Application number: 2025/93140	
What is the application for?:	Installation of replacement shop front and roller shutter (within a Conservation
Address of the site or building:	Kami Healthcare Ltd, 8, Market Place, Birstall, Batley, WF17 9EL
Postcode:	WF17 9EL

Type of comment: An objection	
Do you wish your comments to be published on the website anonymously?	No
2025/93140	
<p>I am writing to object against the above planning application for the old pharmacy in Birstall to be turned into yet another barbers.</p> <p>Firstly the destruction of the original shop front which was listed was absolutely disgusting. The Applicant took it upon himself to disregard not only the need for planning but destroyed the shop windows and frontage with a total disregard for public safety by chucking chairs at the windows to break them whilst people of the Birstall community were going about their daily business. It was only when questions were asked they stopped the work. I believe they knew all too well that they would need planning applications but as we've seen with other buildings around kirklees some people believe that they are above the law and if they put a property in such disrepair that the

Proposed Front Elevation

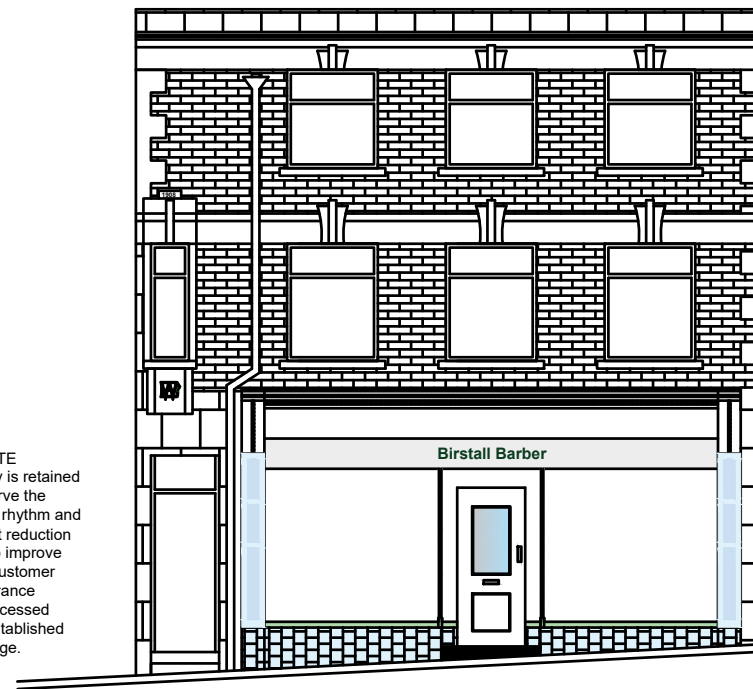
Lastly if this application was to get the go ahead i believe the shop frontage would not be inkeeping with the area and will look cheap and tacky against adjacent properties. The neighbouring property has a canopy that they have had to keep above their shop due to the listed status so will the applicant be made to have a traditional sign? We've already seen that the applicant can't follow the rules so i believe he would not follow any adherements and will do what he wants anyway. We need to preserve what us left in our community and he should be shown that his previous actions have consequences otherwise there is no deterrent.
